Recommendation Report for Planning Permission for Works or Extension to a Dwelling

REF NO: BR/235/21/HH

LOCATION: 15 Mayfield Road
Bognor Regis
PO21 5NA

PROPOSAL: Erection of single storey rear extension

Site Plan (scale 1:500)

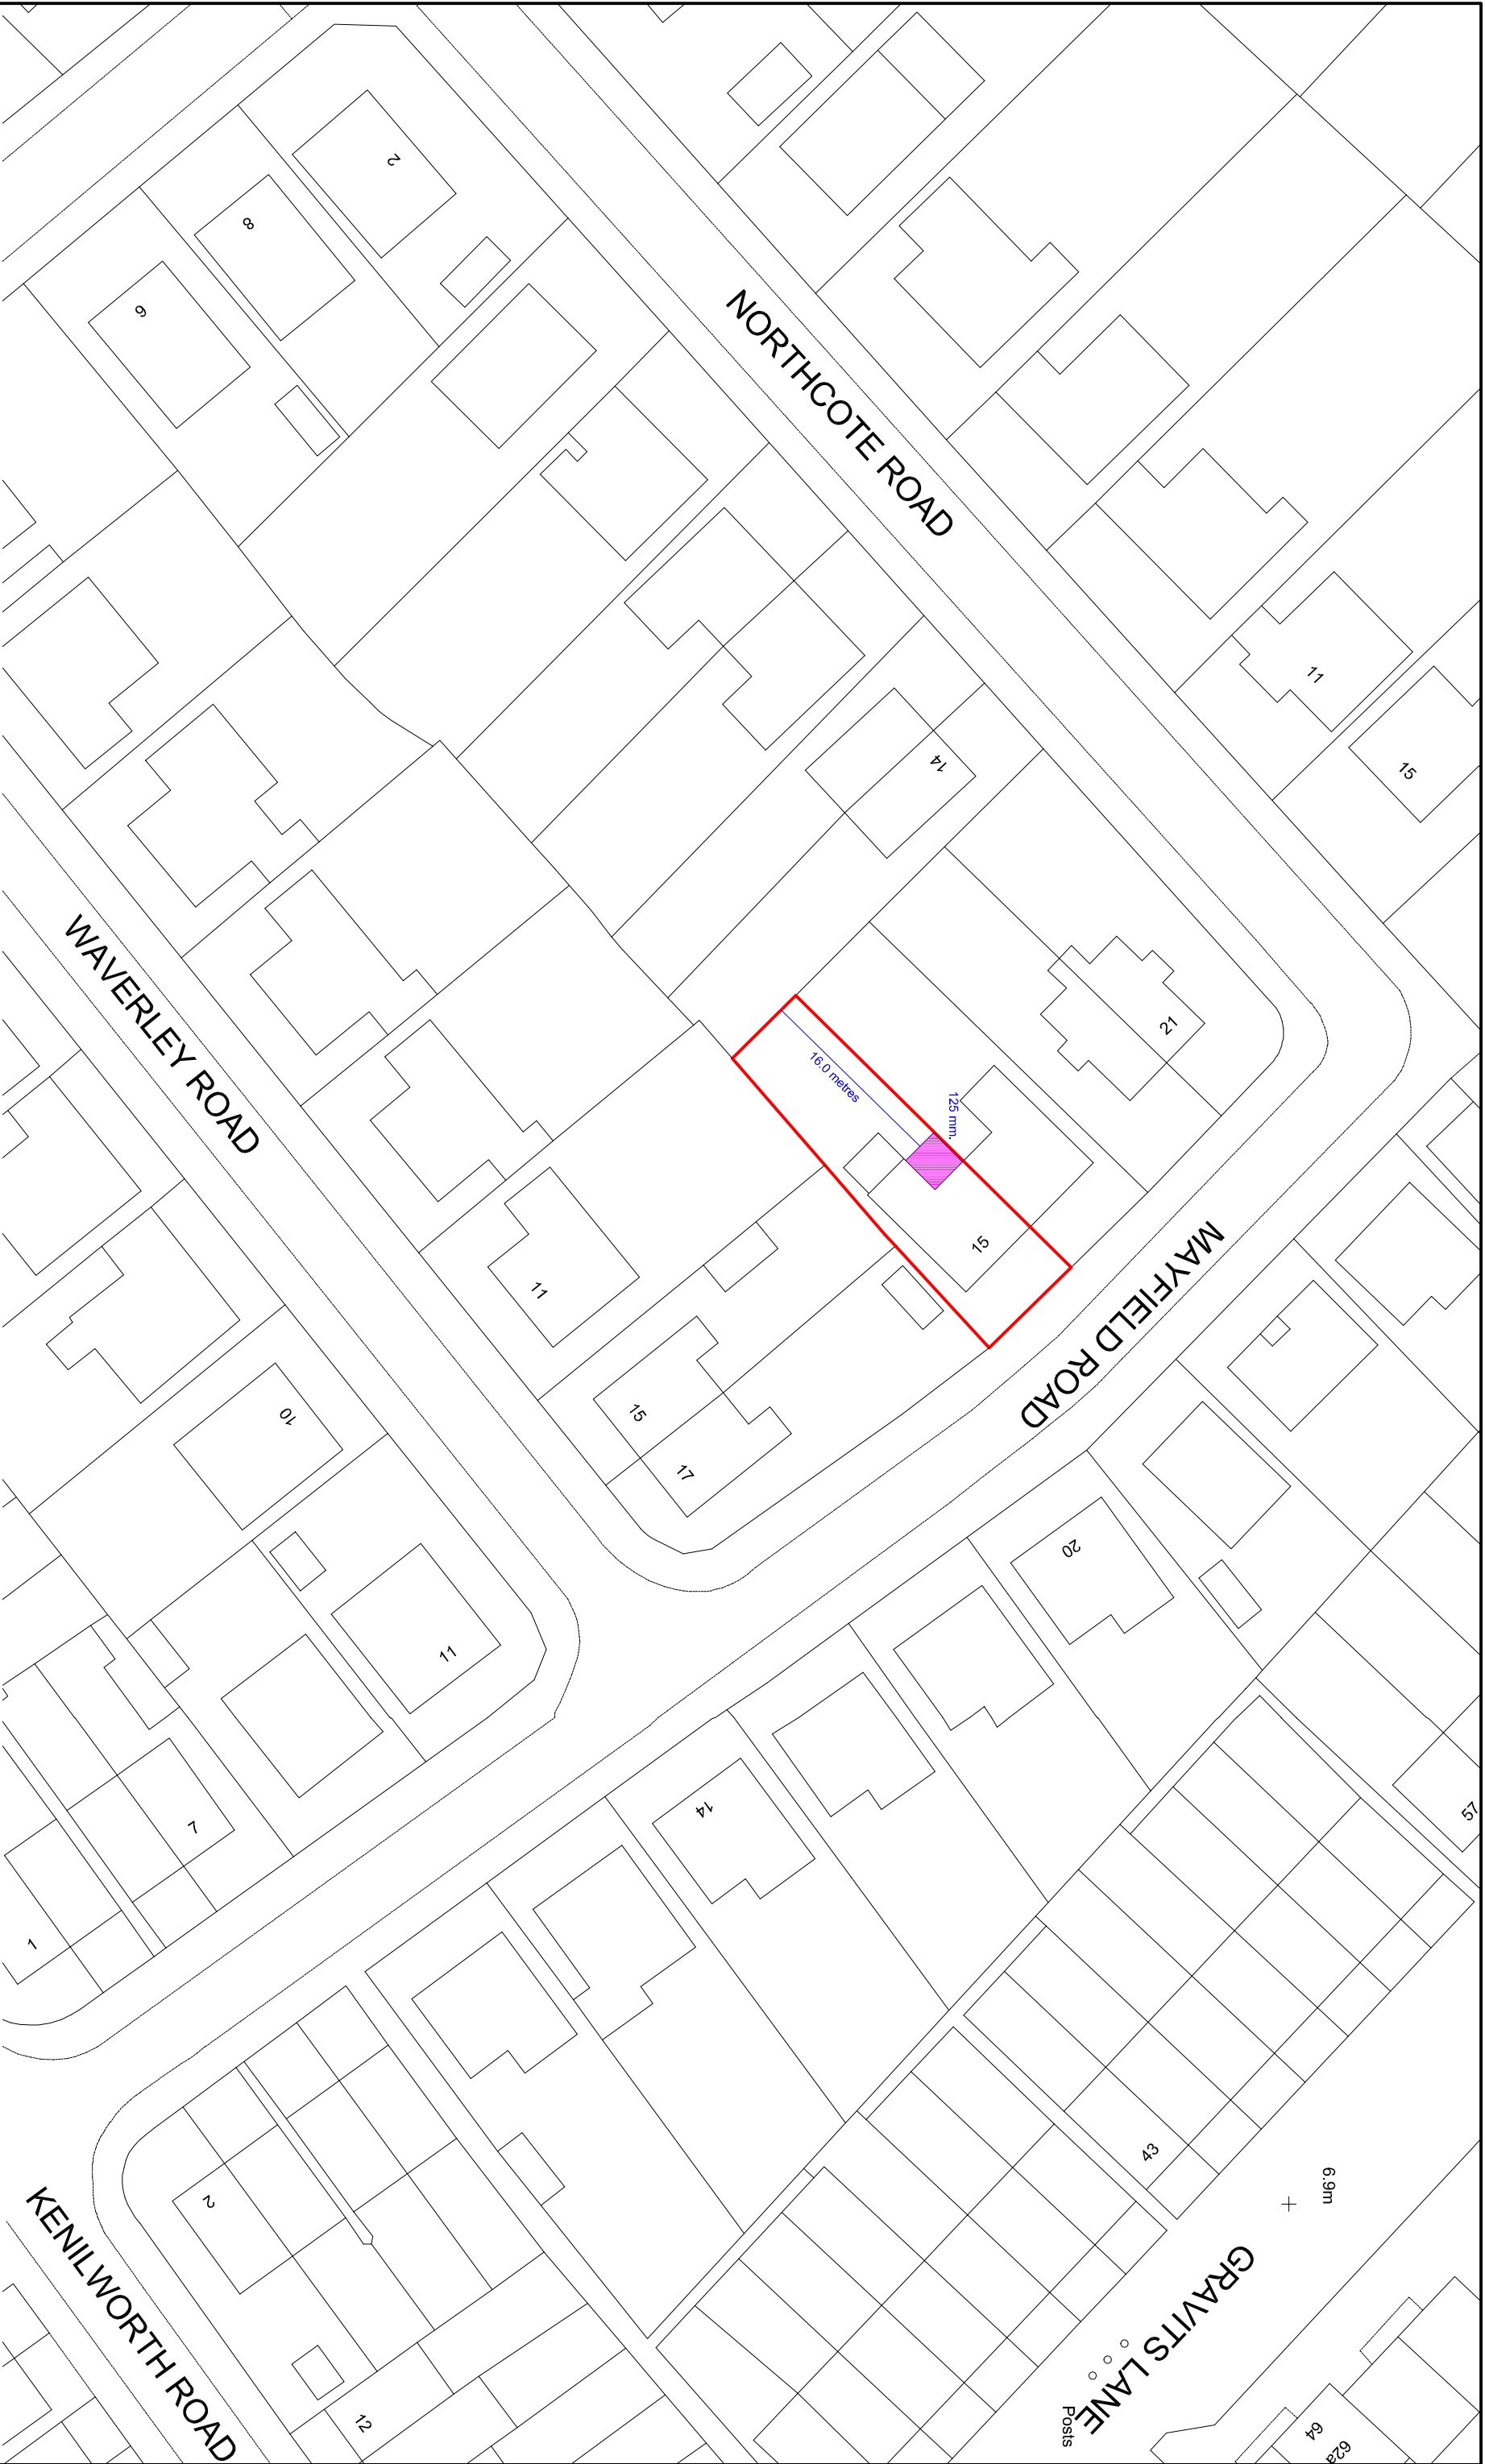
Due to new French doors to rear (west) elevation, large distance of around 16.0m retained to the rear (west) boundary and boundary fence to side (north west) there is no adverse harm to overlooking to neighbouring amenity so is acceptable.

PROPOSED GROUND FLOOR PLAN

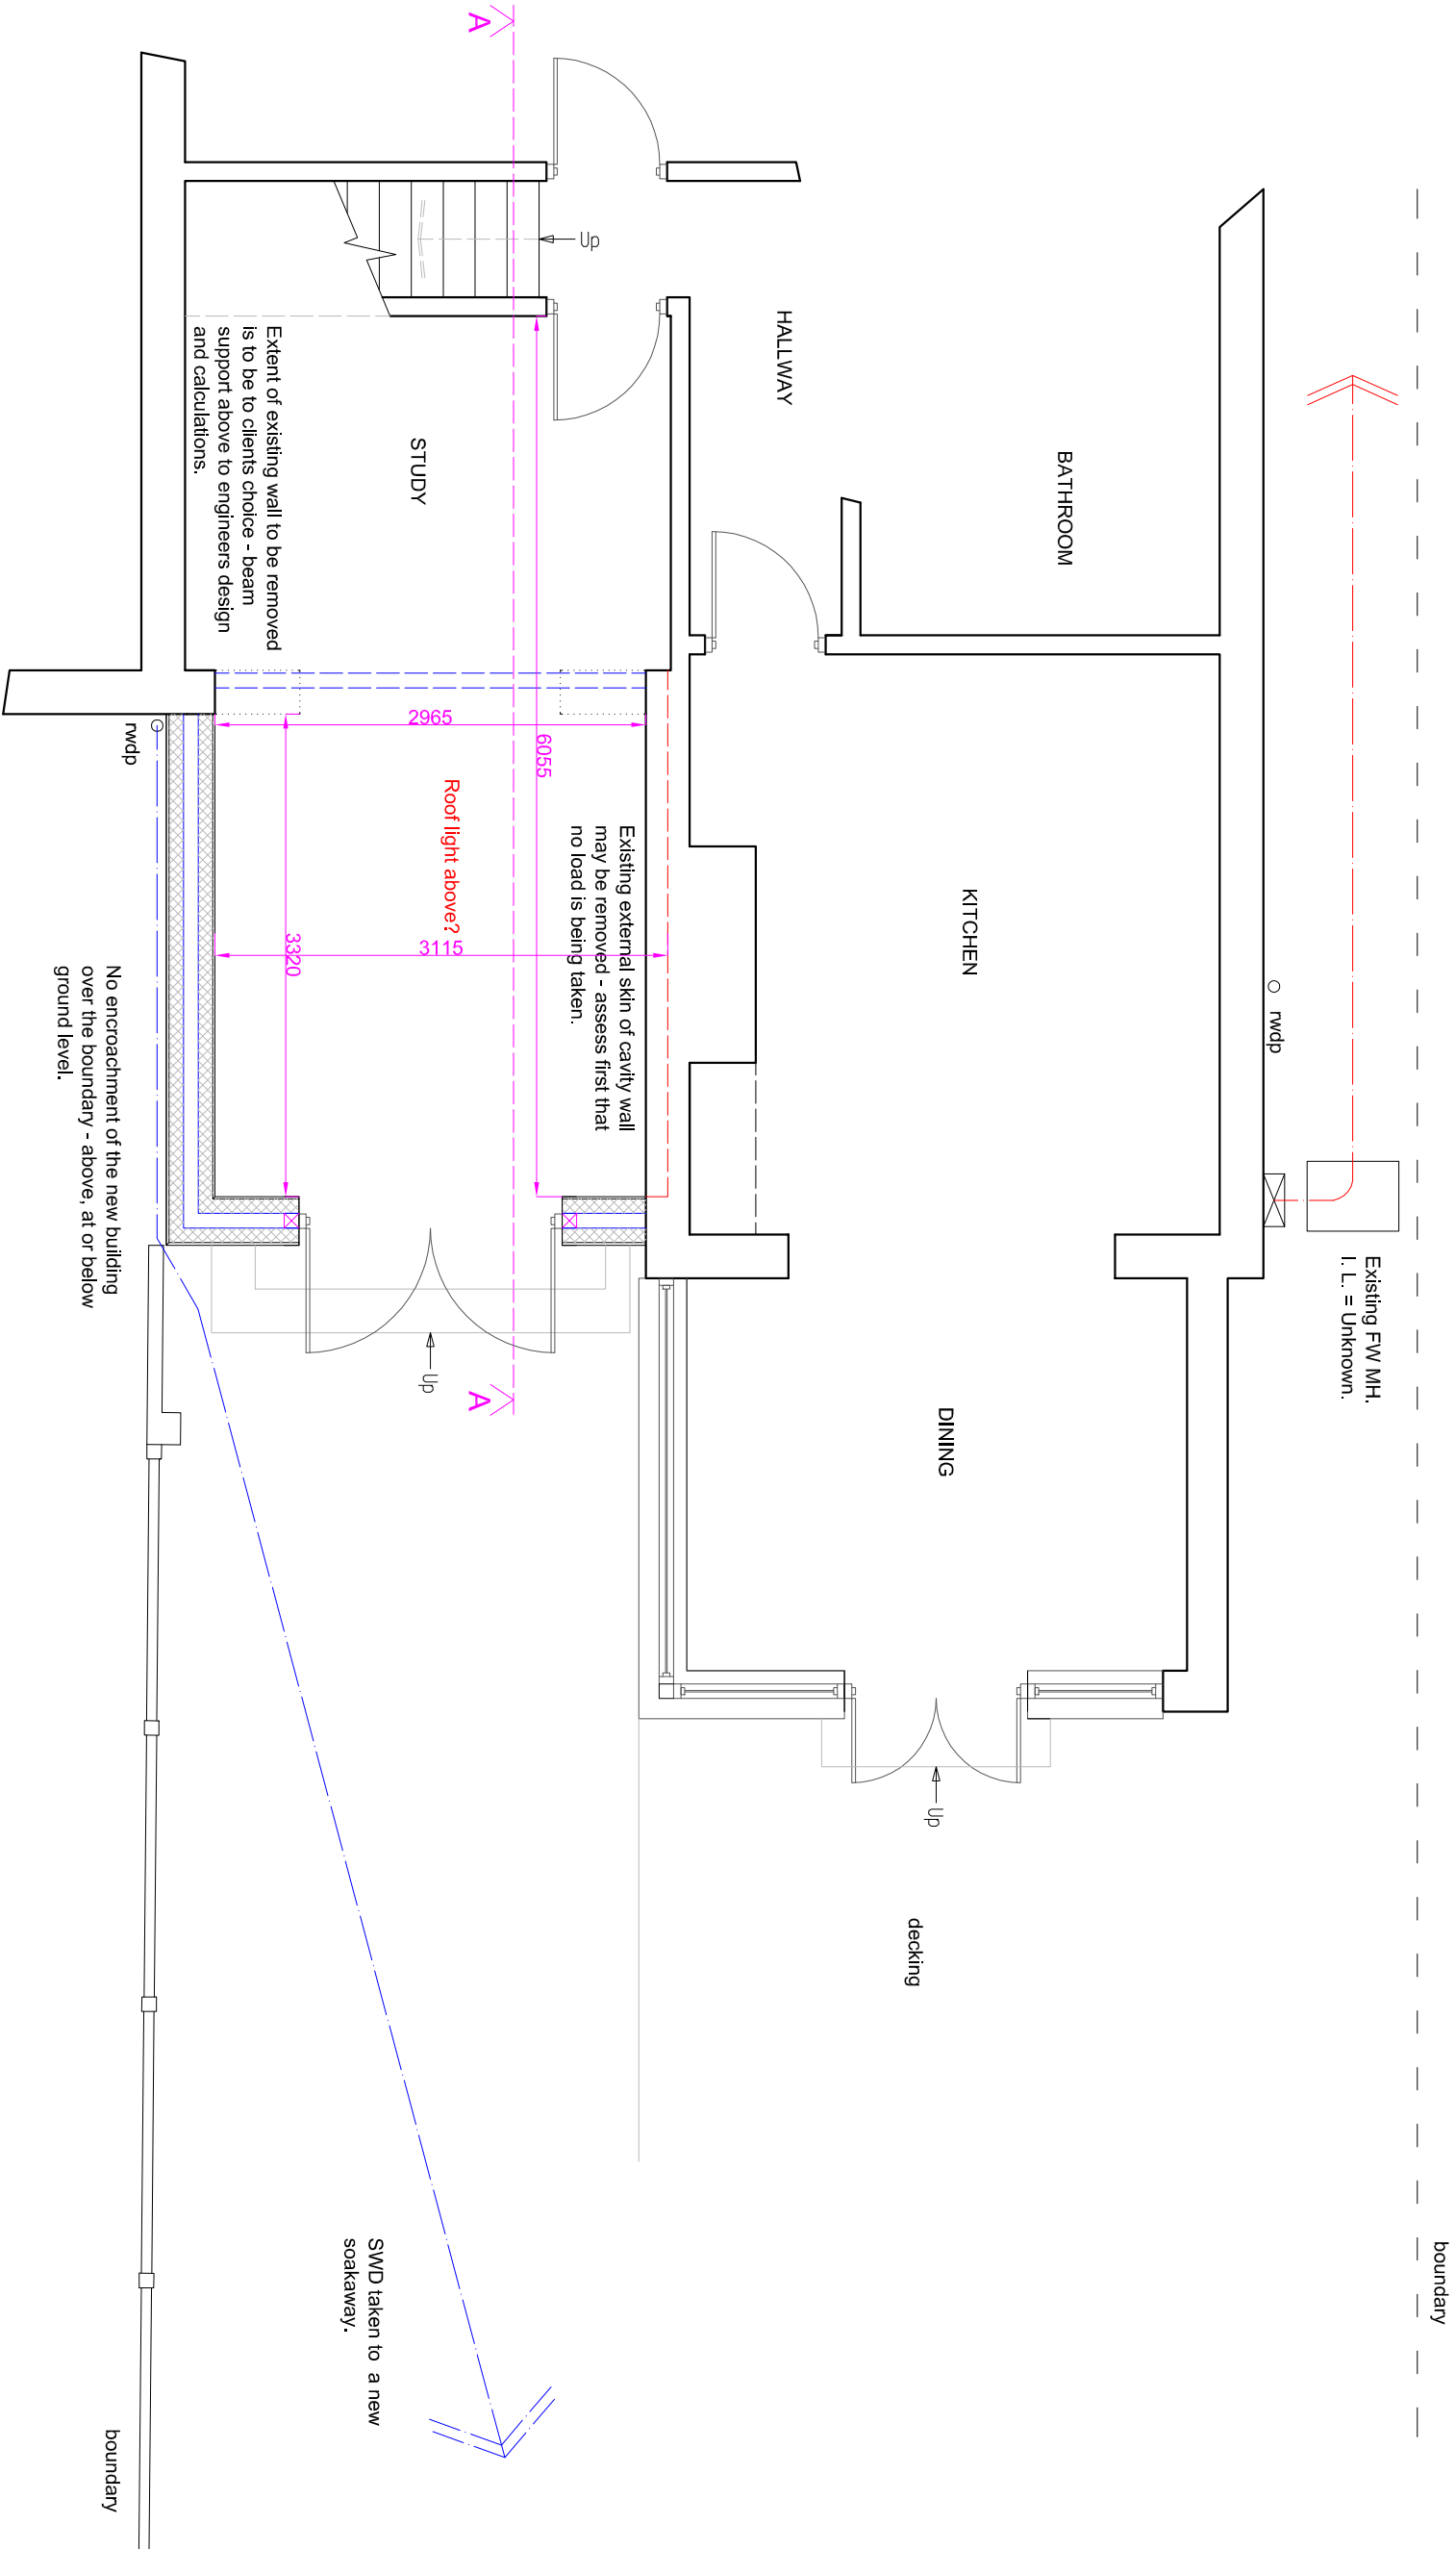
The proposal is for a single storey rear extension to be sited to the rear (north west) corner to infill rear north west elevation. It will retain a gap of around 3.28m to the rear (west) dining room / conservatory elevation. Due to siting to rear it will not be visible from street scene so will not adversely impact street scene or surrounding character of area so complies with policy D DM1 of the Arun Local Plan.

There is a gap of around 0.067m retained to the side (north west) and 16.0m retained to the rear (west) boundary.

It states in semi-detached houses, by keeping single-storey extensions no more than 3.3 metres from the rear elevation of the original dwelling. The proposal is greater in depth at 3.64m but not excessively so is acceptable.

Due to only a small gap of around 0.067m retained to the side (north west) boundary there is increased risk of overshadowing or overbearing impact to no. 17 to north west. The proposal will not pass the 45 degrees test however it is considered a similar proposal could be done under Permitted Development at a lower height so the impact caused is not enough to warrant a refusal.

PROPOSED ELEVATIONS

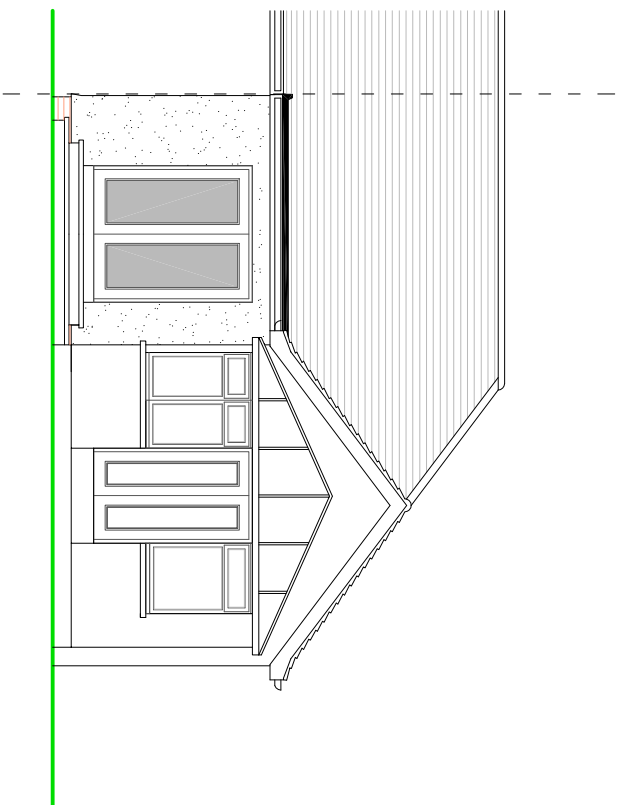
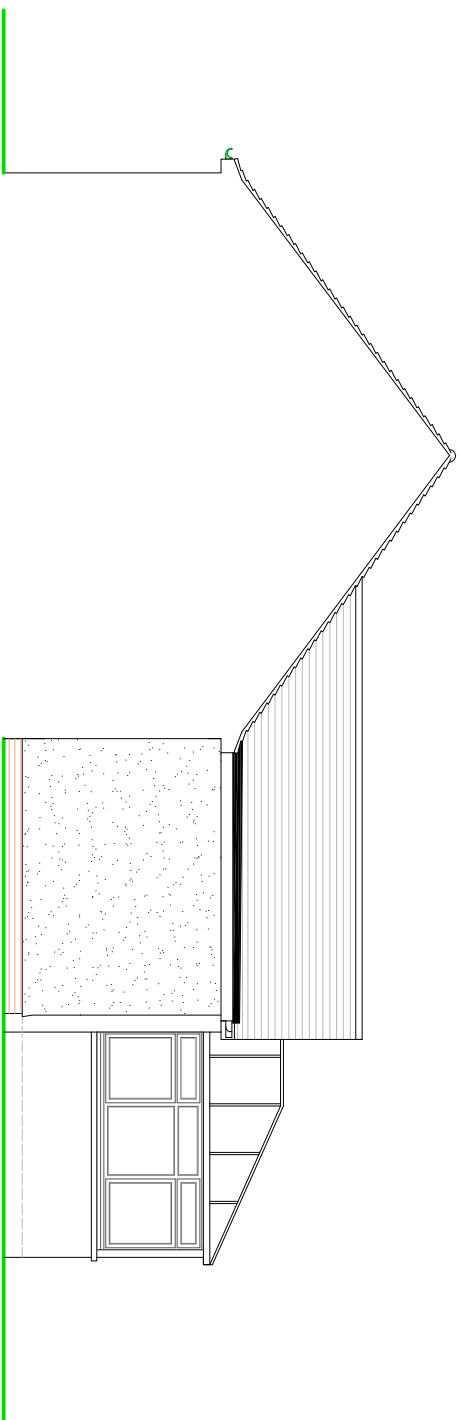
The proposal has a width of approximately 3.29m and a depth of approximately 3.64m. The height to top of flat roof will be approximately 3.12m.

There will be one new set of French doors with a raised steps entry to west elevation facing garden to rear.

The proposed materials seem to match existing dwelling and consist of mixture of painted render and face brickwork to walls, GRP covering to flat roof and white framed UPVC double glazed windows and

doors so complies with policy D DM1 and D DM4 of the Arun Local Plan.
